3 February 2021
 Our Ref: 2517 / DPIE Ref: SSI-9487

RE: Submission in relation to the Inland Rail – Narromine to Narrabri (SSI-9487)

Prepared by:	Jim Lawler, Associate, Groundwork Plus Pty Ltd PO Box 1779, Milton BC QLD 4064 P: 07 3871 0411, M: 0406 680 969, E: jlawler@groundwork.com.au
On behalf of:	Regional Quarries Australia Pty Ltd
In relation to:	Inland Rail – Narromine to Narrabri (SSI-9487)
Submission:	Objection
Reasons:	<ol style="list-style-type: none"> 1. Chapter C3 of the N2N EIS identifies exceedances of noise, vibration and air quality criteria for the operation of the borrow pits which would not ordinarily be acceptable for an Extractive industry. 2. The N2N EIS has not considered whether dust from the resource at the borrow pits could result in a human health risk for respirable crystalline silica. 3. The borrow pits for the N2N should be held to the same assessment criteria and operational obligations as a commercial quarry operation. 4. The N2N has not considered the most likely haulage routes for quarry materials from existing quarries in Dubbo and should be revised to include an assessment of impacts of construction traffic on the Mitchell Highway, Tantitha Roa

Figure A1.3 Key construction infrastructure (map 1)

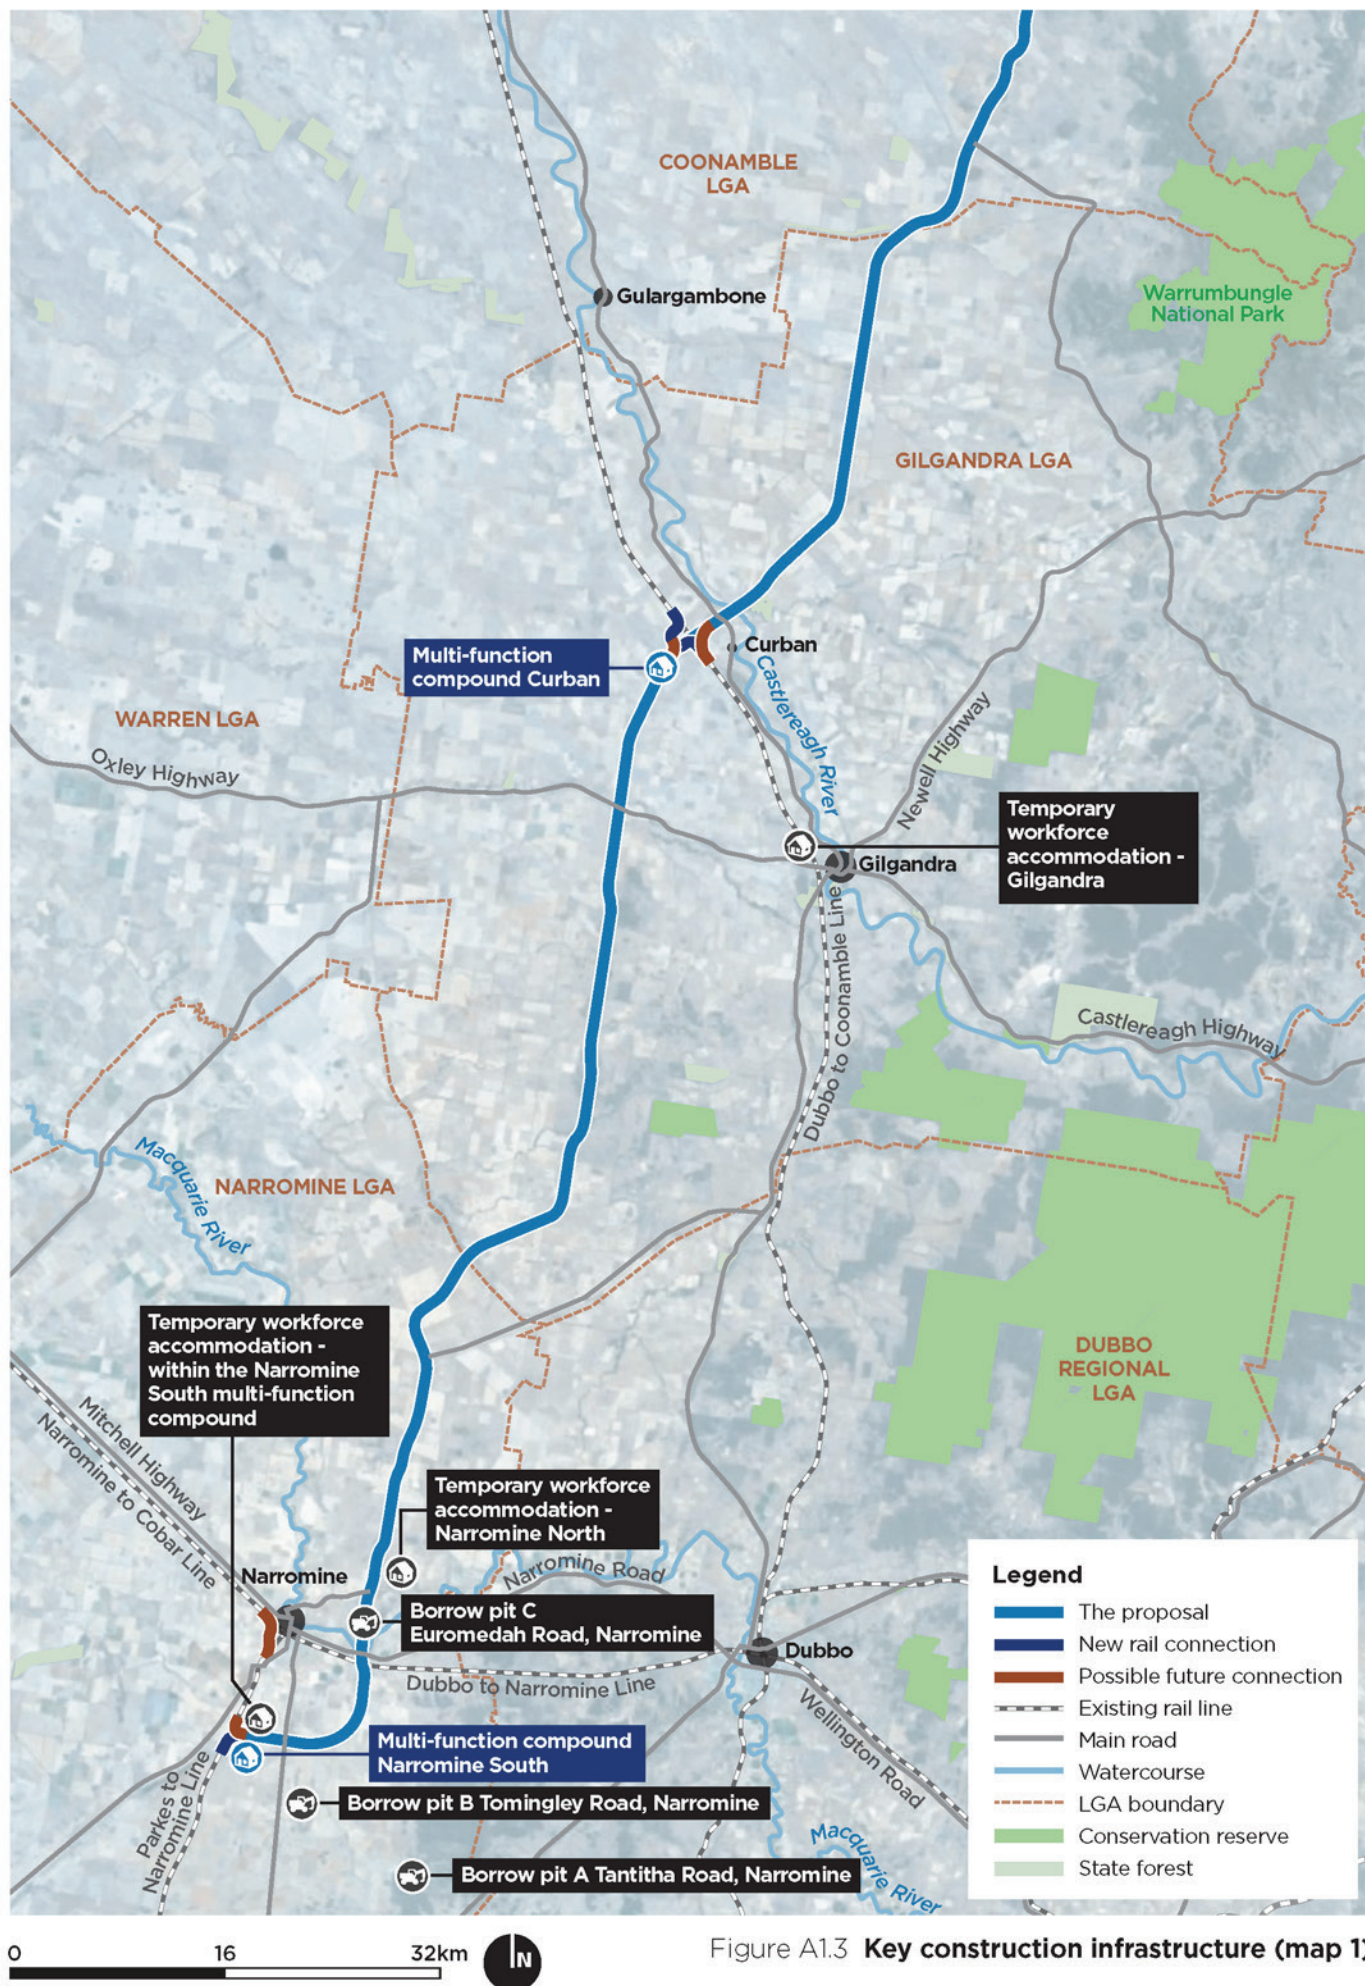
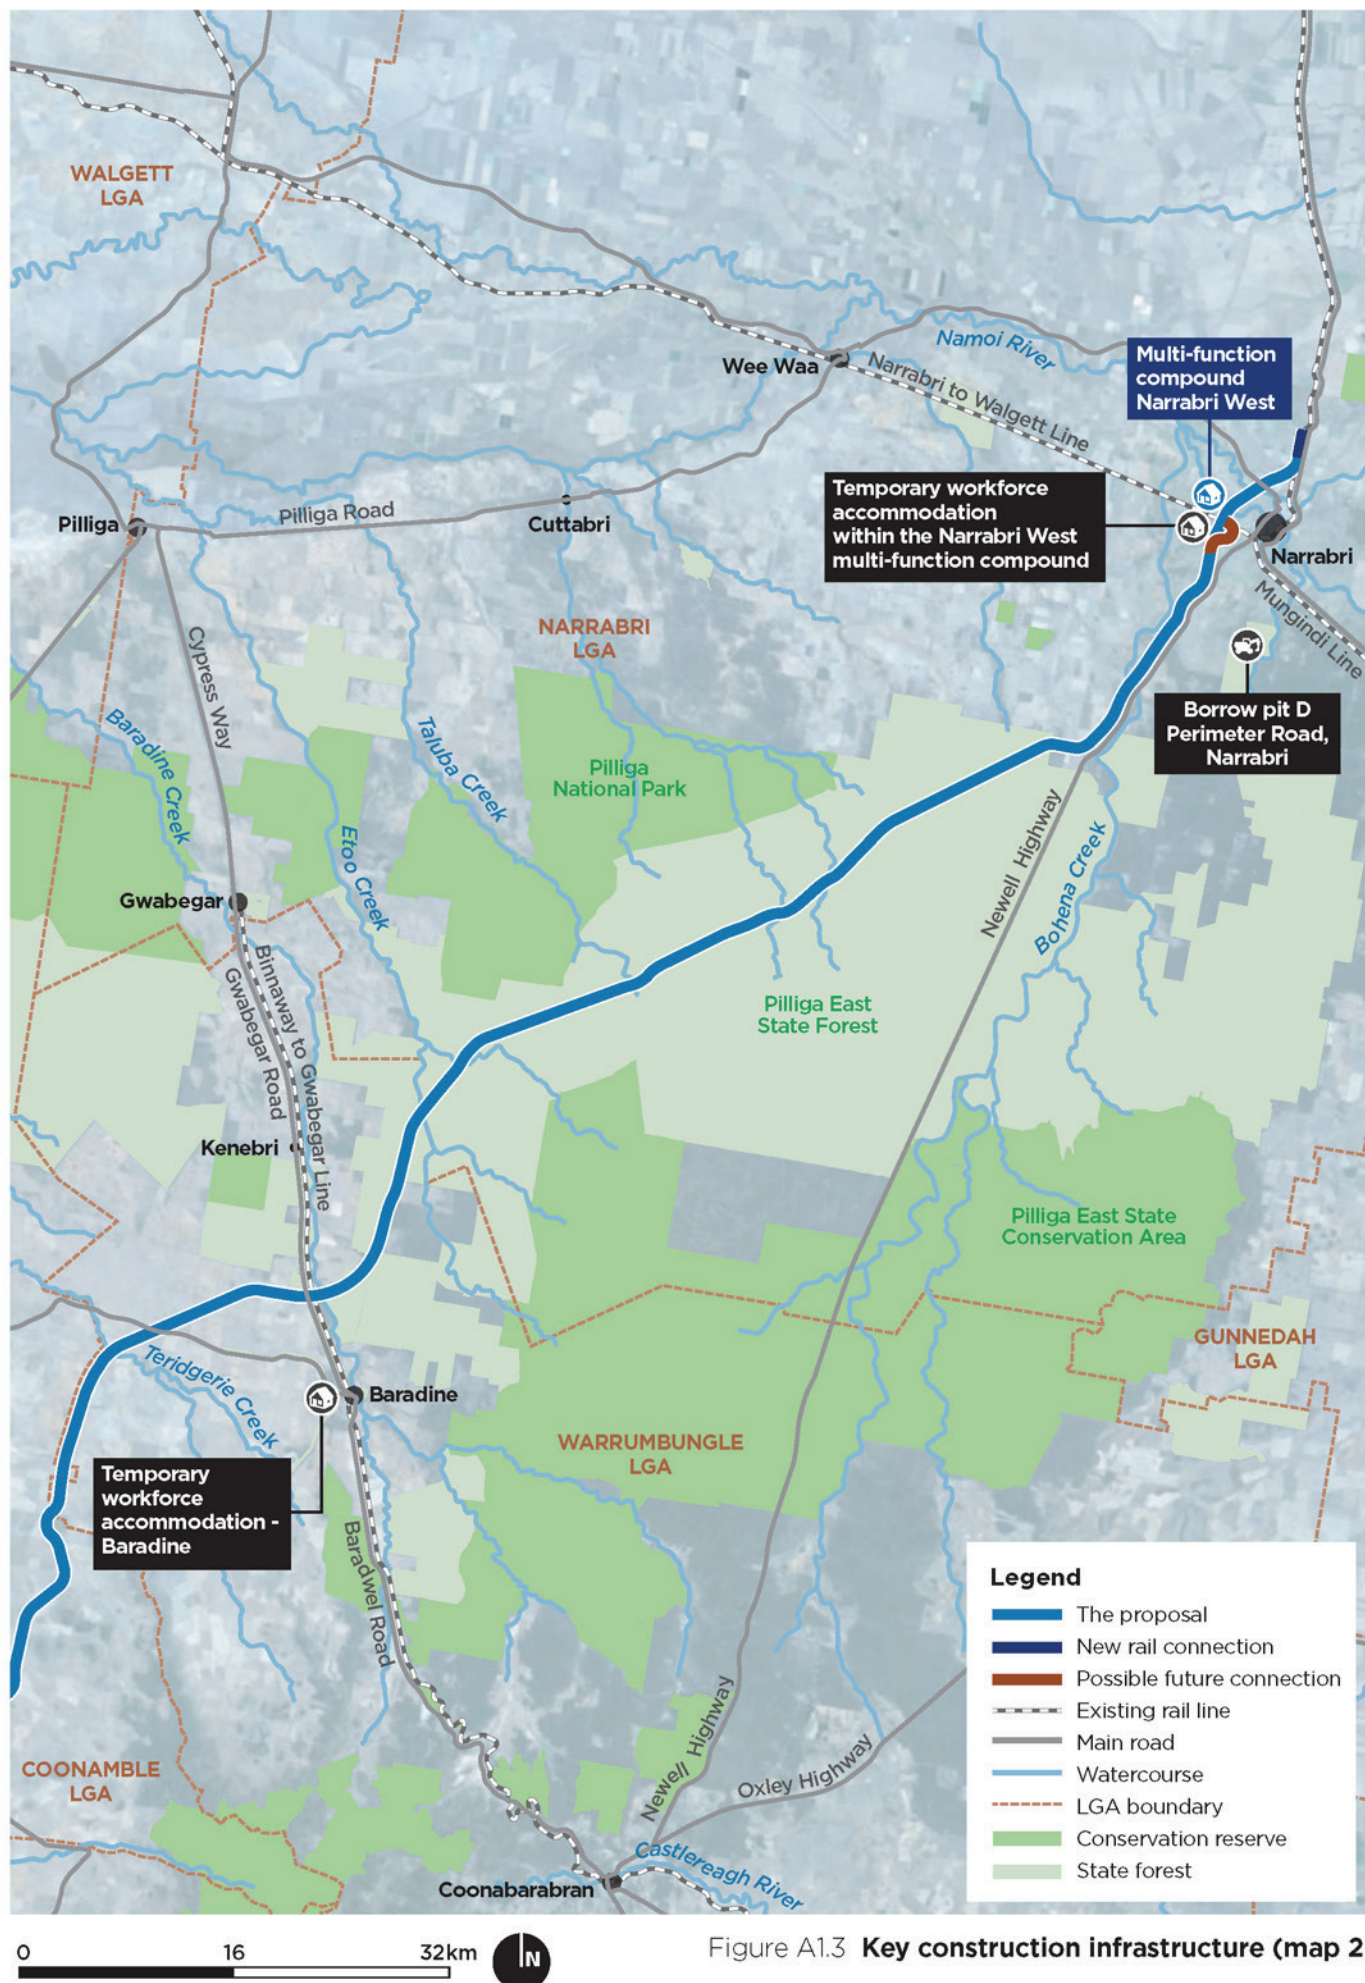
The location of Borrow pit A, B and C is shown on Figure A1.3 of the N2N EIS. Borrow pit A and B are in proximity to the Redden Quarry and Borrow pit C is adjacent to the Macquarie Manor Quarry.
